Y/22/19/PL

The proposal site consists of a former garage on Main Road, Yapton. The garage building itself is a single storey structure that is in a poor state of repair. It appears to be a former flint and brick barn which has been extended and altered in order to accommodate its former use. It is set back some distance from a listed building, and is read as a back-land, industrial styled development. Whilst it is set back from the road, it is still visible from it.

I note that this application is a revision to a previously approved scheme. The current proposal seeks to build a replacement structure on a slightly smaller footprint than the existing building. The justification for the loss of the existing structure is that it is structurally unsound.

street elevation as proposed

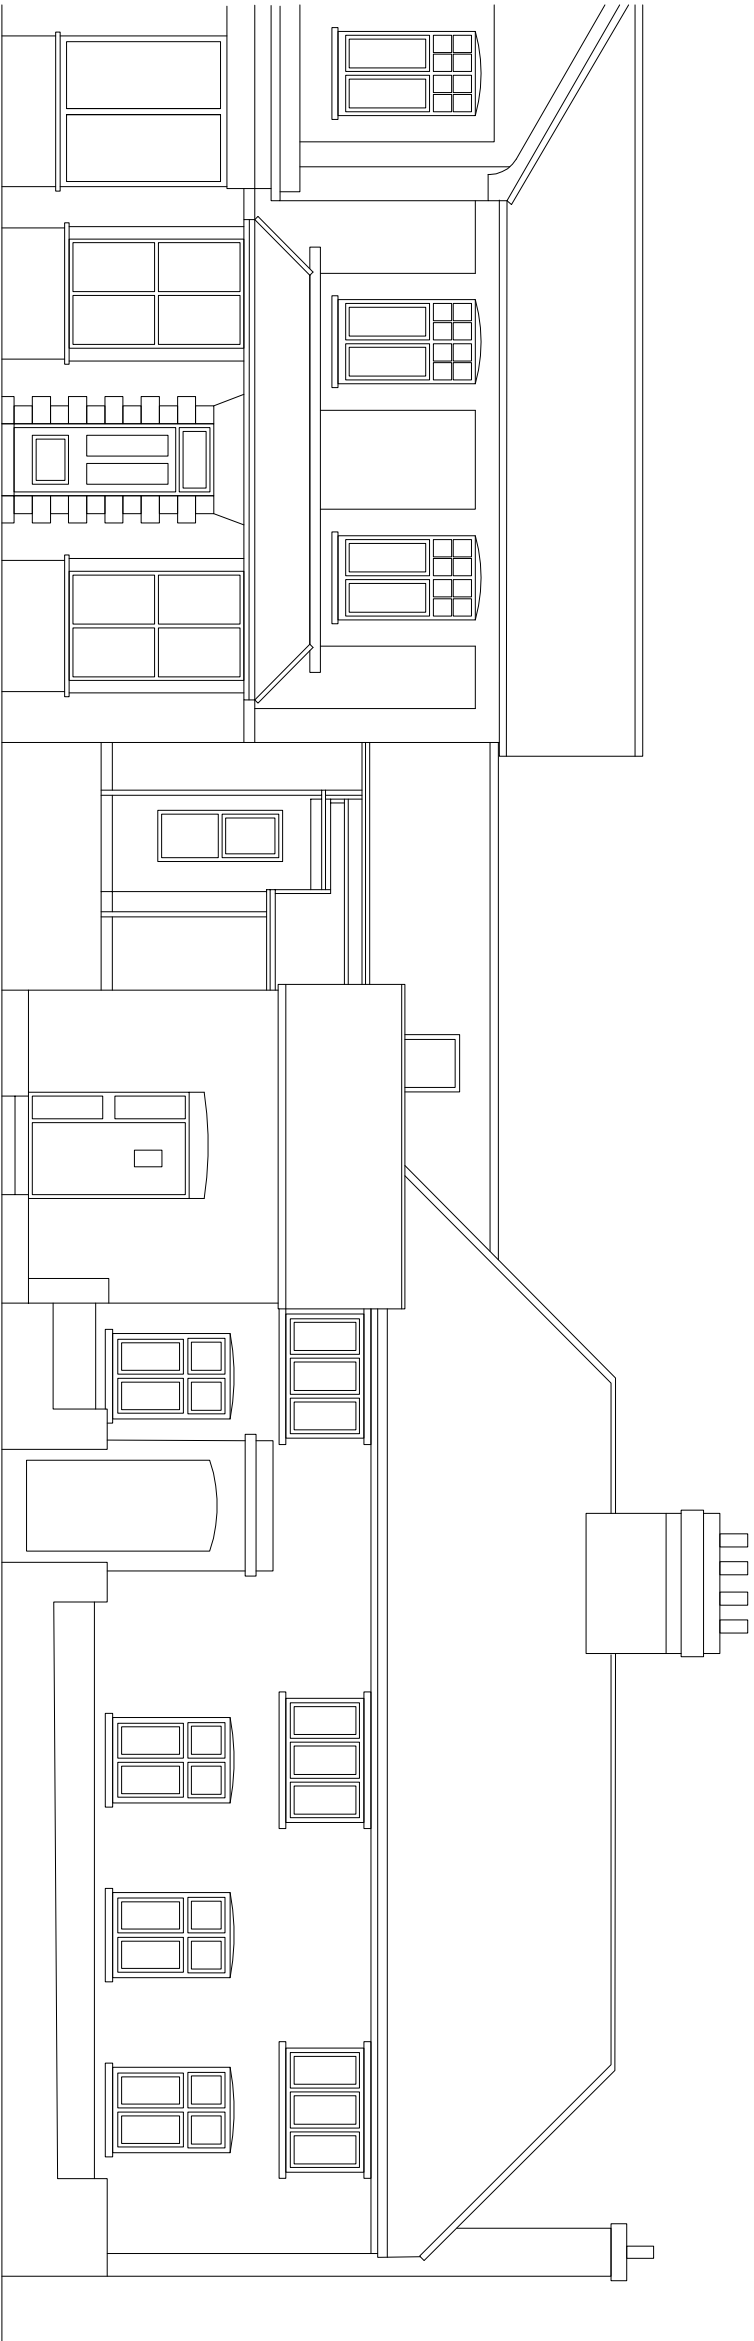
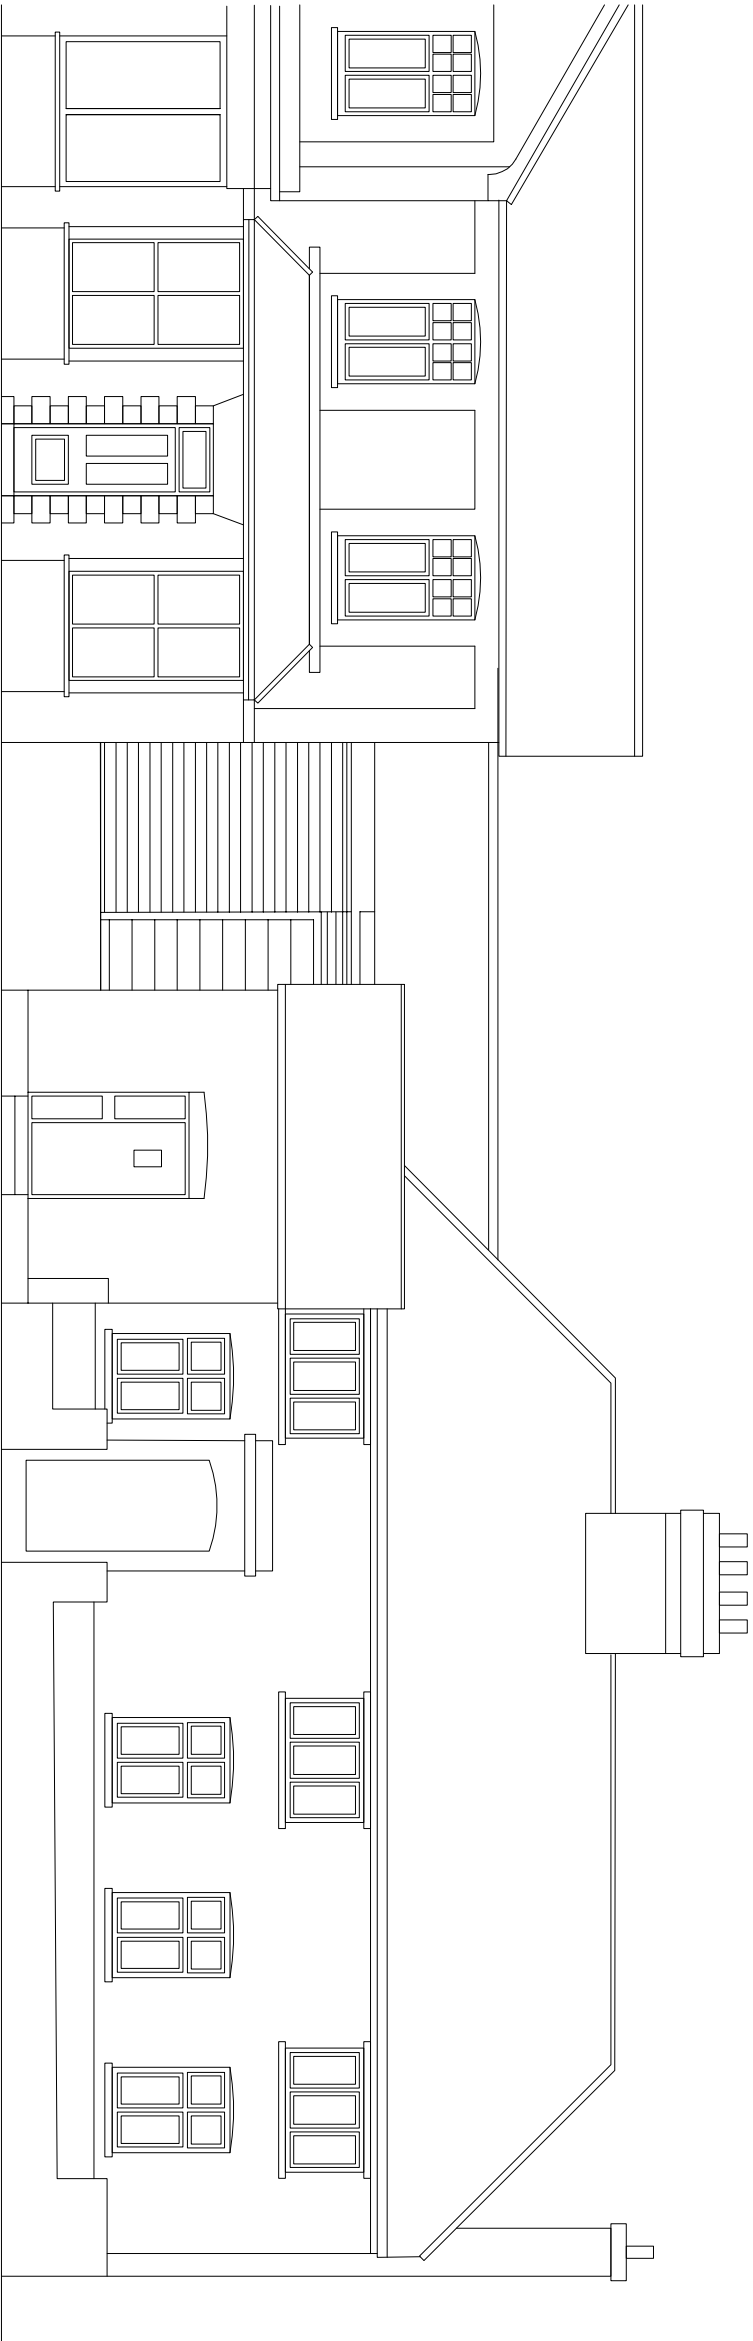
The replacement structure will have a similar profile to the existing building, but create a one and a half storey dwelling. I note that the intention is to retain the existing flint walling and insert the new structure within it. This will ensure that it retains some of the older elements of the site. I also note that the appearance of the building is such that it will reflect that of the existing structure; i.e. one of a more industrial aesthetic.

As the proposal consists of a simplistic design and palette of materials, the quality of the materials and works will need to be high. You may wish to condition the materials in order to ensure that they reflect the character of both the site and the local area. Details of the windows and rooflights should also be provided by way of condition. The rooflights should be of conservation standard.
